WRITTEN RESPONSE TO THE EXAMINER, PLANNING INSPECTORATE

RE: APPLICATION BY FOSSE GREEN ENERGY LIMITED – EN010154

WRITTEN SUBMISSION FROM COLEBY PARISH COUNCIL

Principal Site Internal Cable Route
Corridor

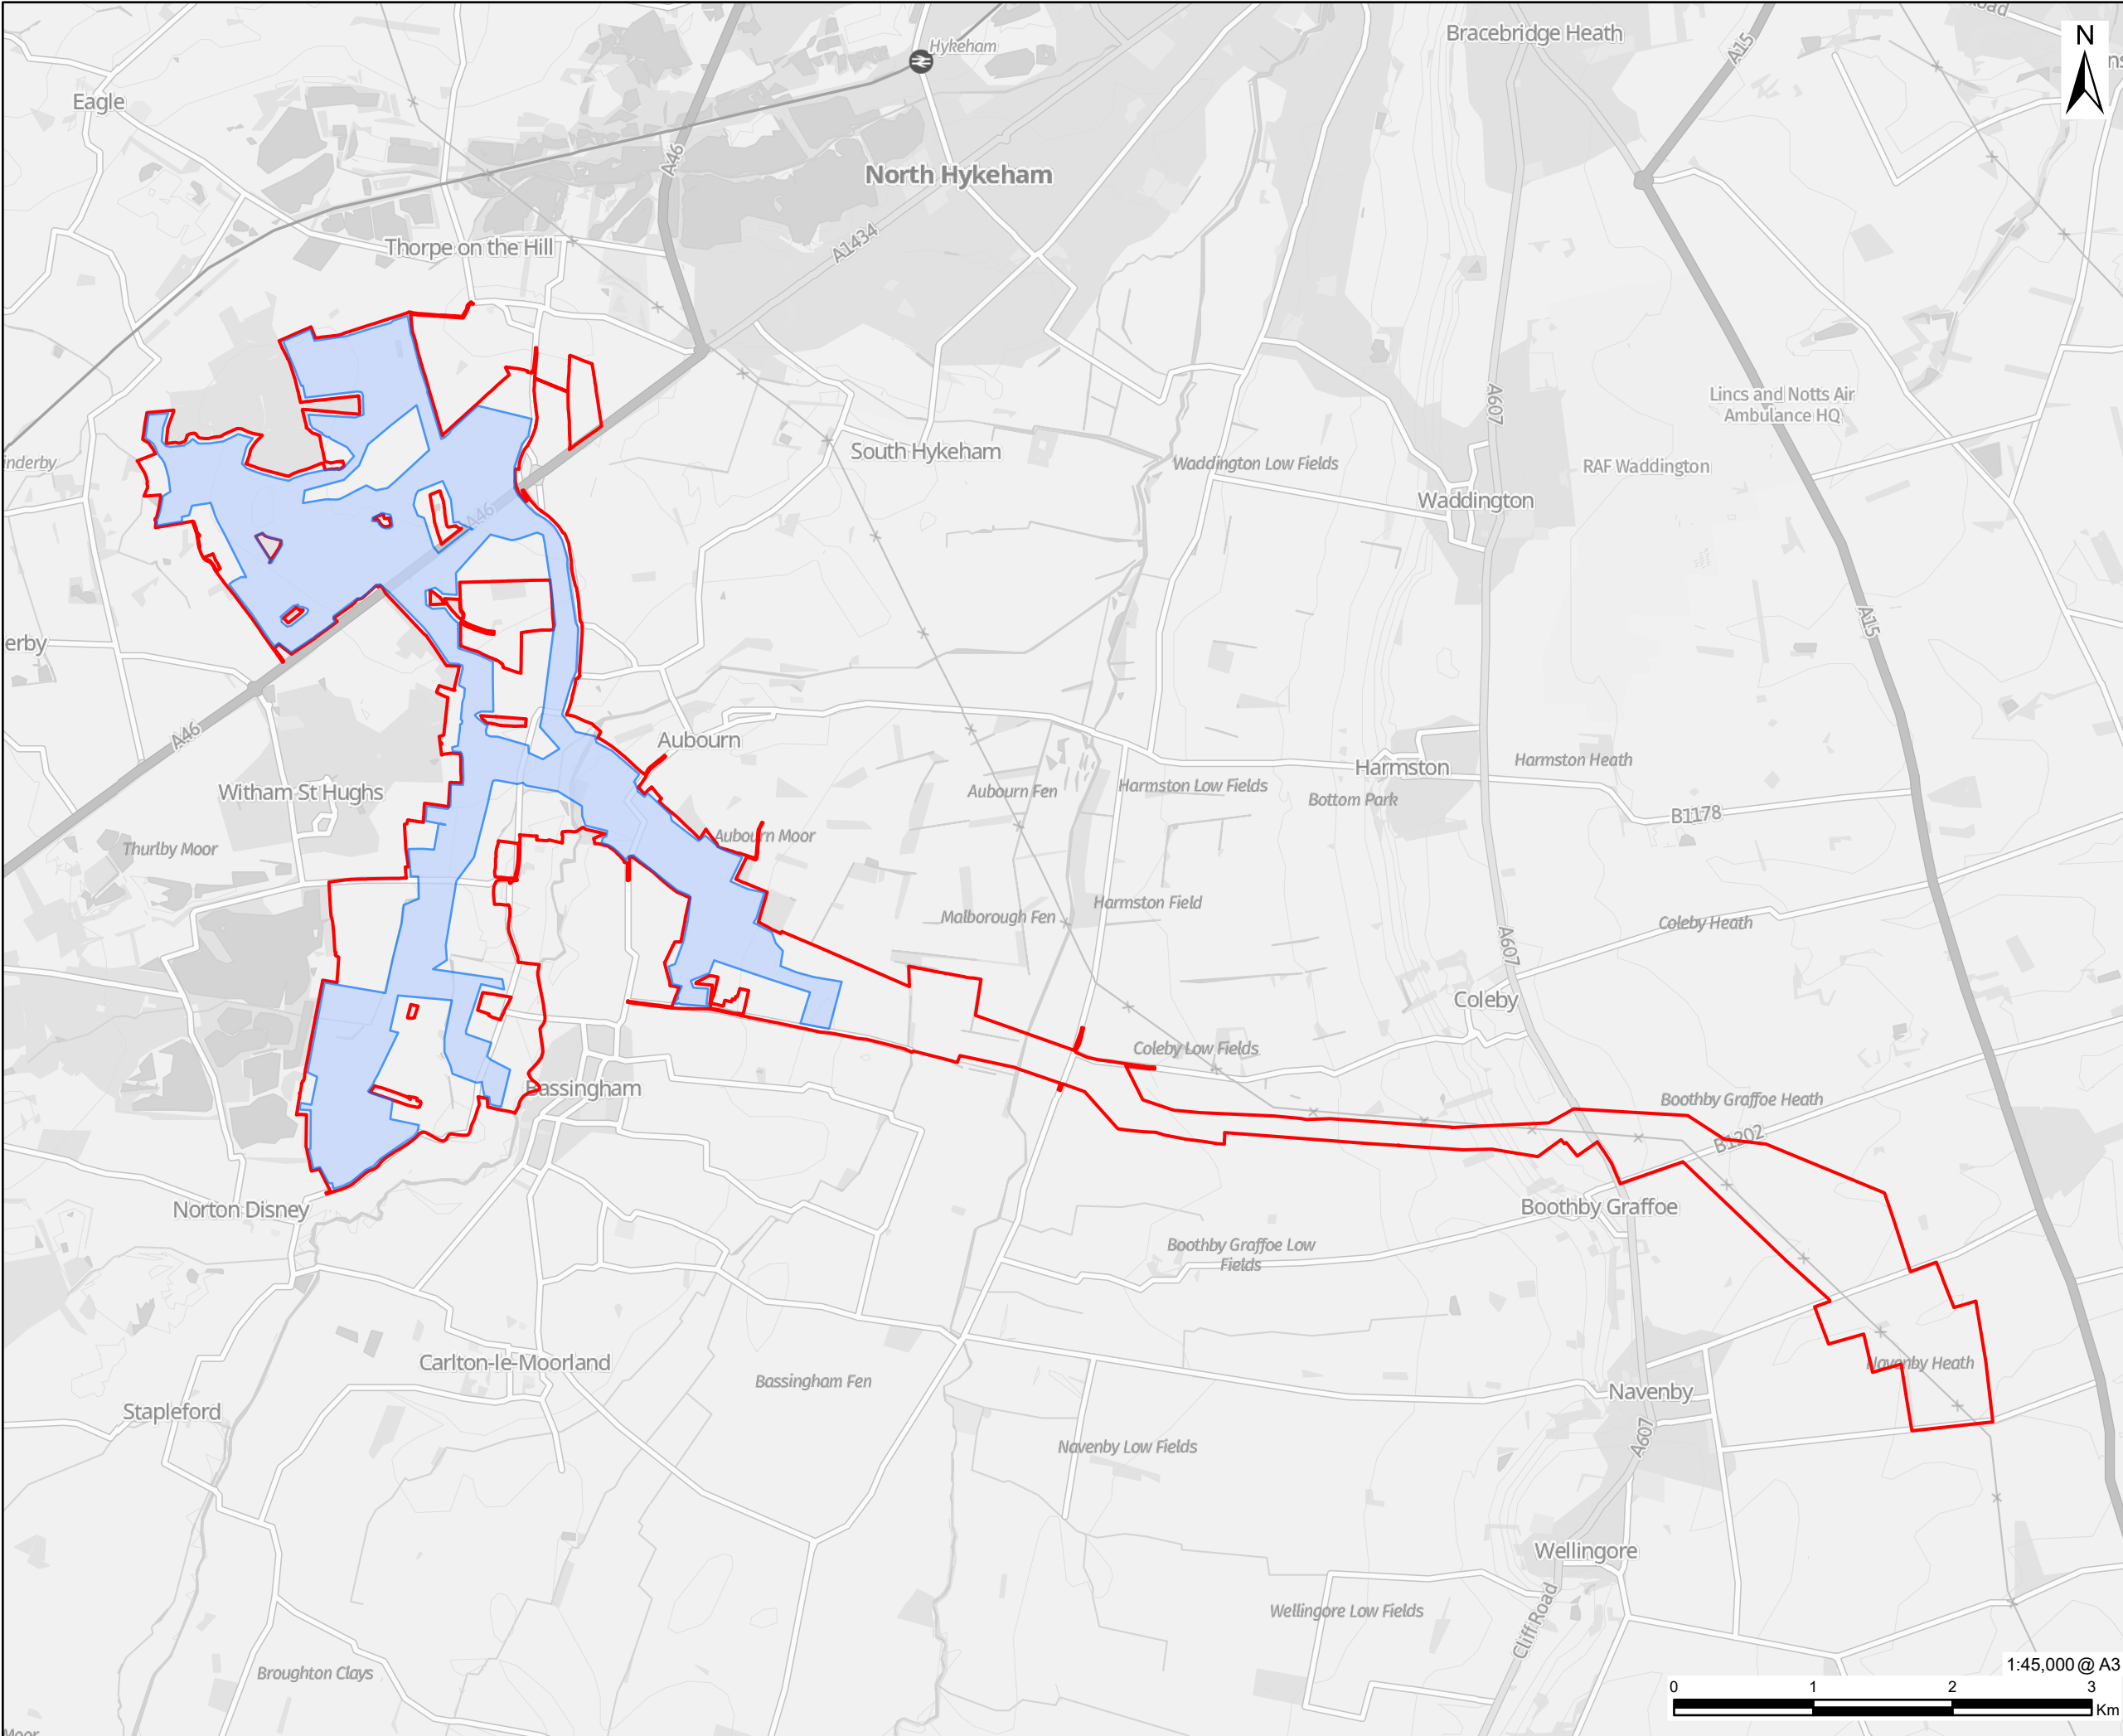
Can the Inspector arrange for more detail to be provided on the size of, and what permanent physical features, will be above ground level for the 10km length of the corridor, once the site is complete? This should also include whether or not any features above ground will be removed at the Decommissioning stage.

The Council is concerned that the underground grid connection cable corridor will be left in situ at the decommissioning stage, and that this will lead to toxins and PFAS leaching into the soil and watercourses as the casings and wires deteriorate over time.
